Response to Council Letter Dated 25 August 2010

Traffic	
<p>Council’s Traffic Management Section has reviewed the proposed development and provides the following comments:-</p>	
<p>a) Previous proposals for the subdivision and road network of the Bungarribee</p>	<p>All internal roads are to be dedicated to Council in accordance with the approved</p>

Stormwater & Drainage

Scope of Works & Subdivision Plan

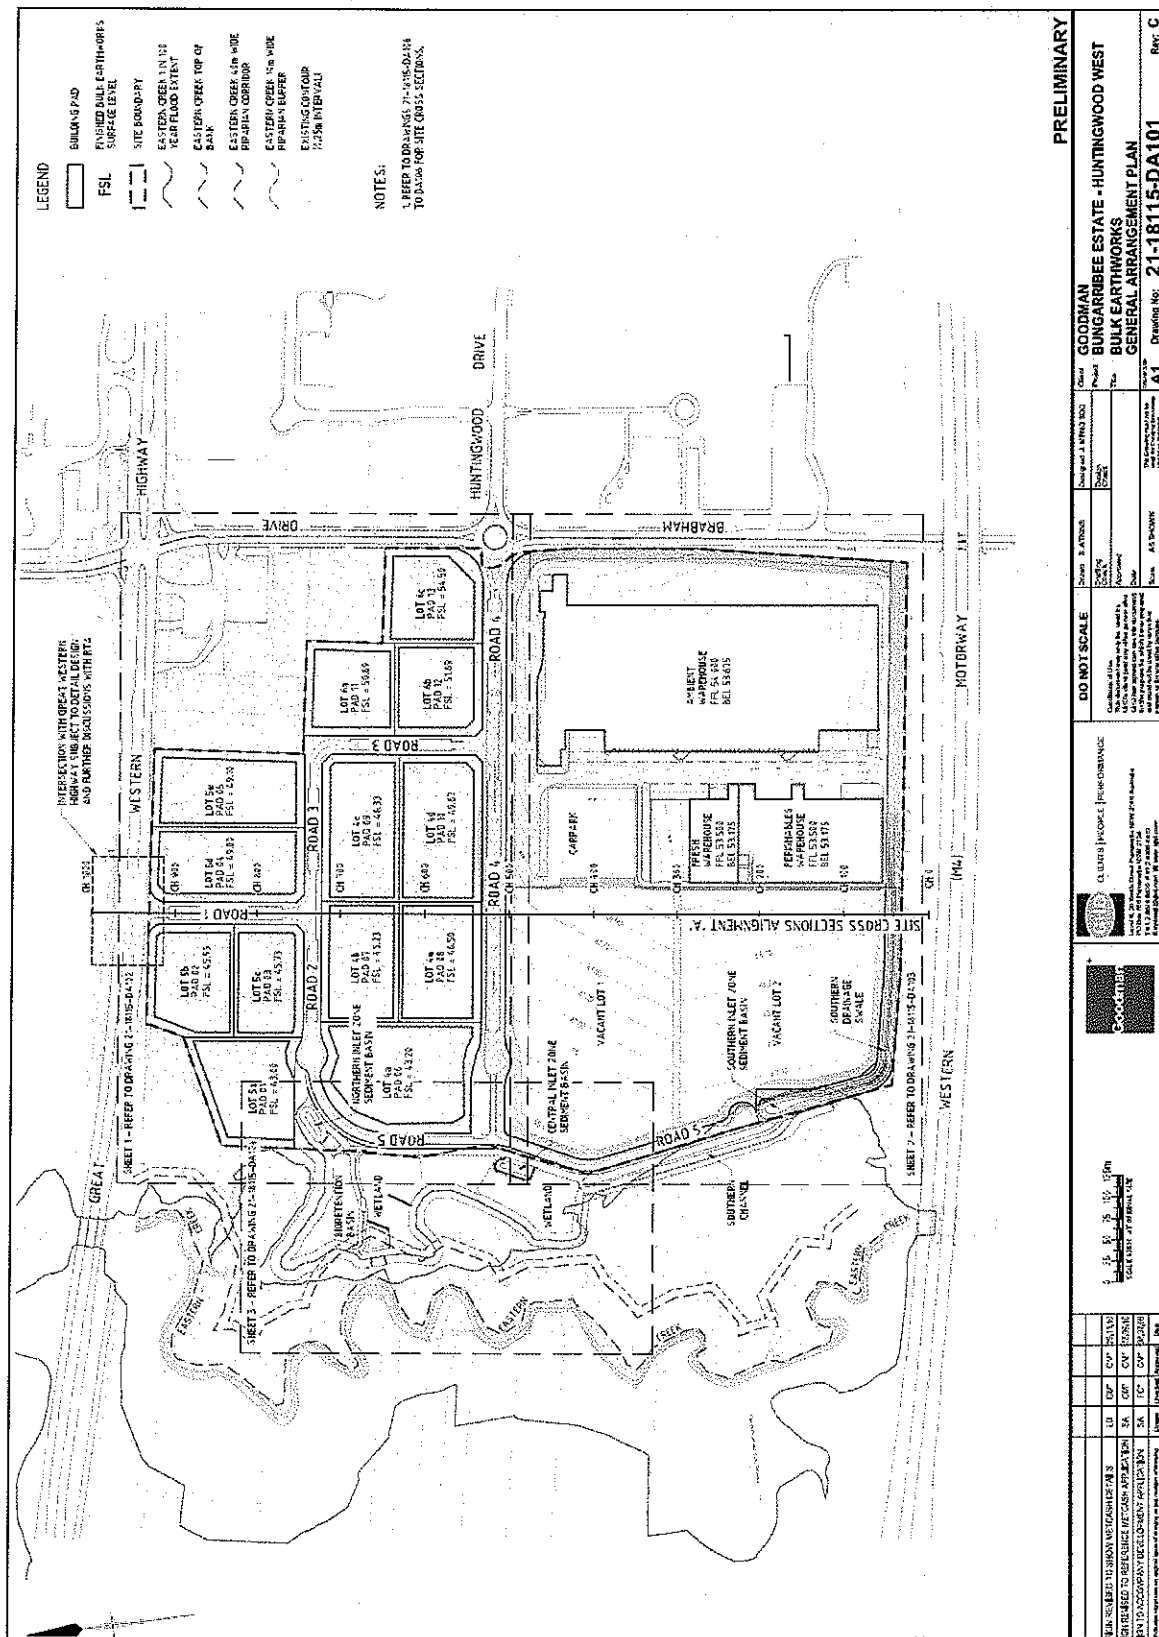
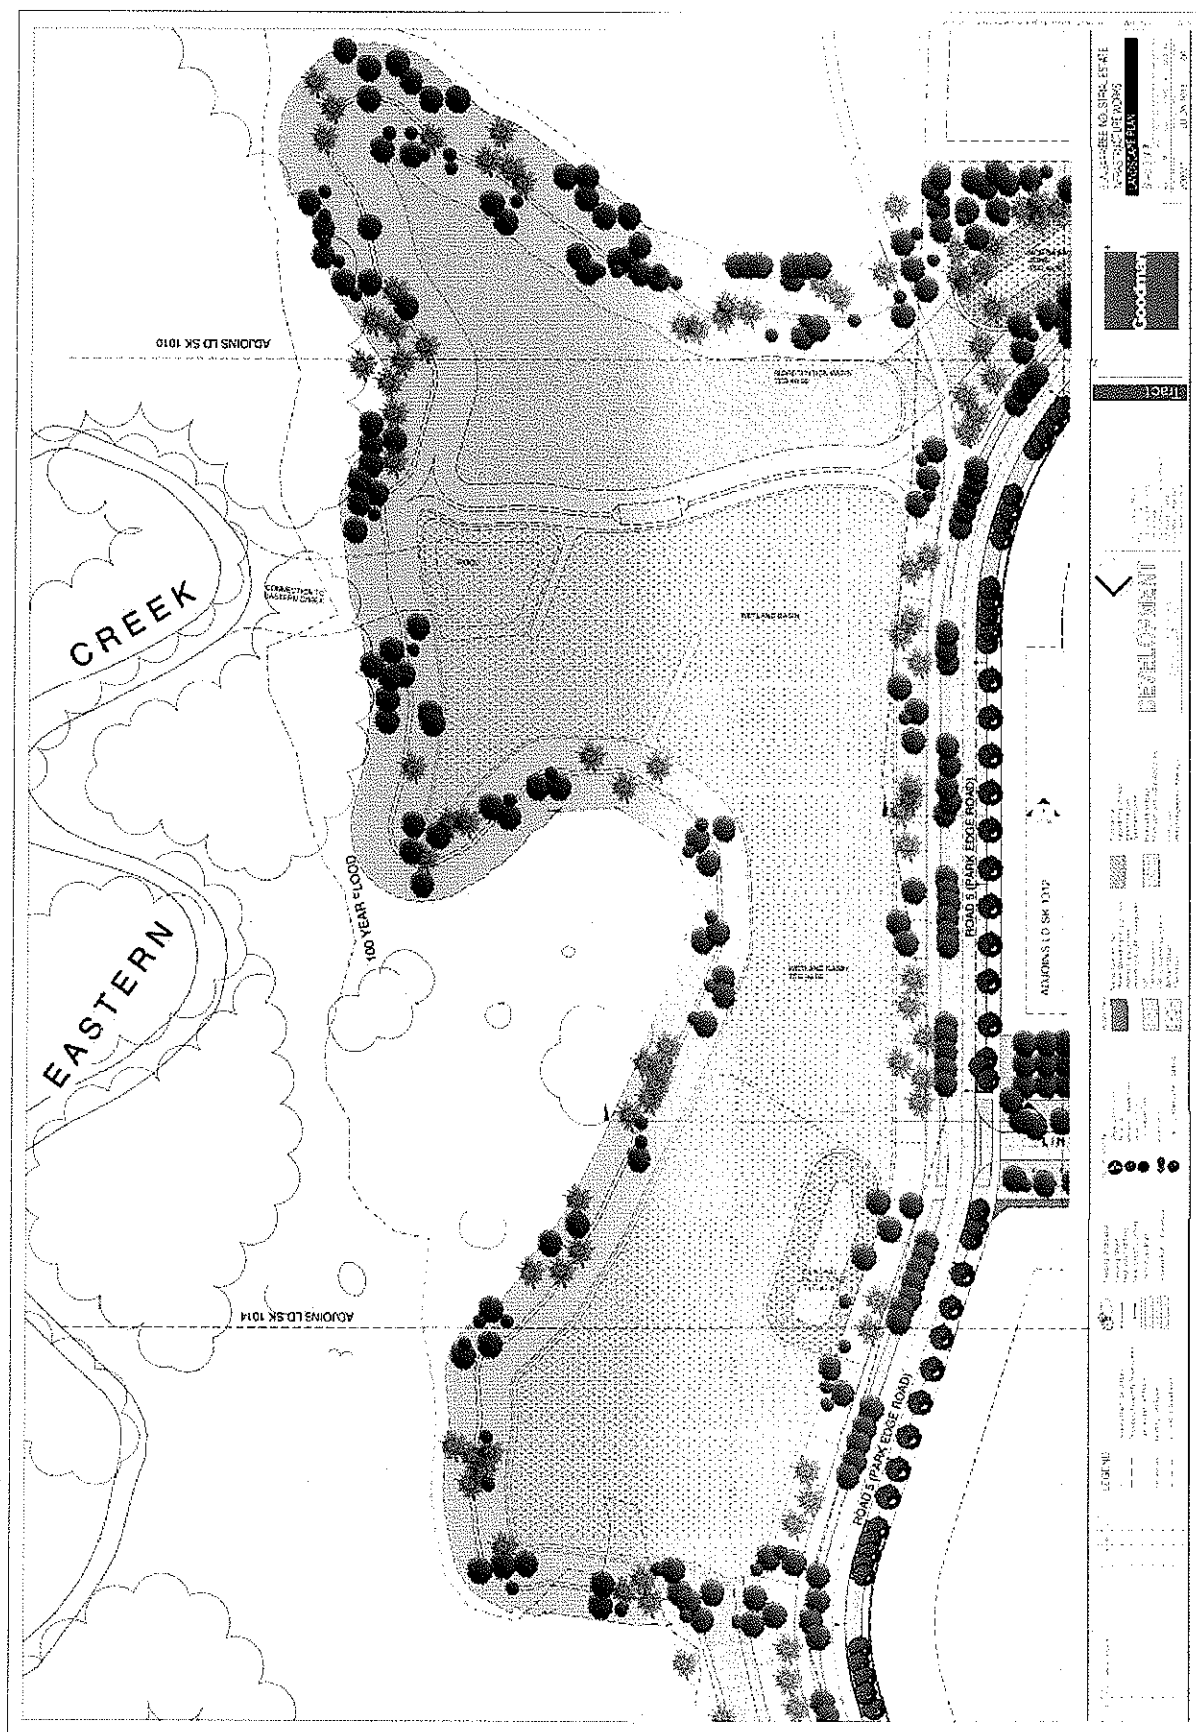
The proposed subdivision and internal estate road layout is inconsistent with the Preliminary Environmental Assessment (PEA) prepared by Goodman Property Services (Australia) Pty Ltd dated 10 June 2010, received by Council from the Department of Planning on 12 August 2010, for the construction and operation of a warehouse and distribution centre in the Bungaribee Industrial Estate at Huntingwood West.

The warehouse and distribution centre is proposed to be constructed on Lot 3 and part of Lot 2 within the Bungaribee Industrial Estate. This indicates that the development would be constructed over Road 3 (Local Road) proposed under this current application.

Clarification should be provided on how the PEA relates to the current Environmental Assessment under review. Alternatively, these applications shall be amended to correspond in terms of the subdivision and internal road layout to avoid future modifications to the proposals.

This inconsistency has been addressed and rectified with this revised application.
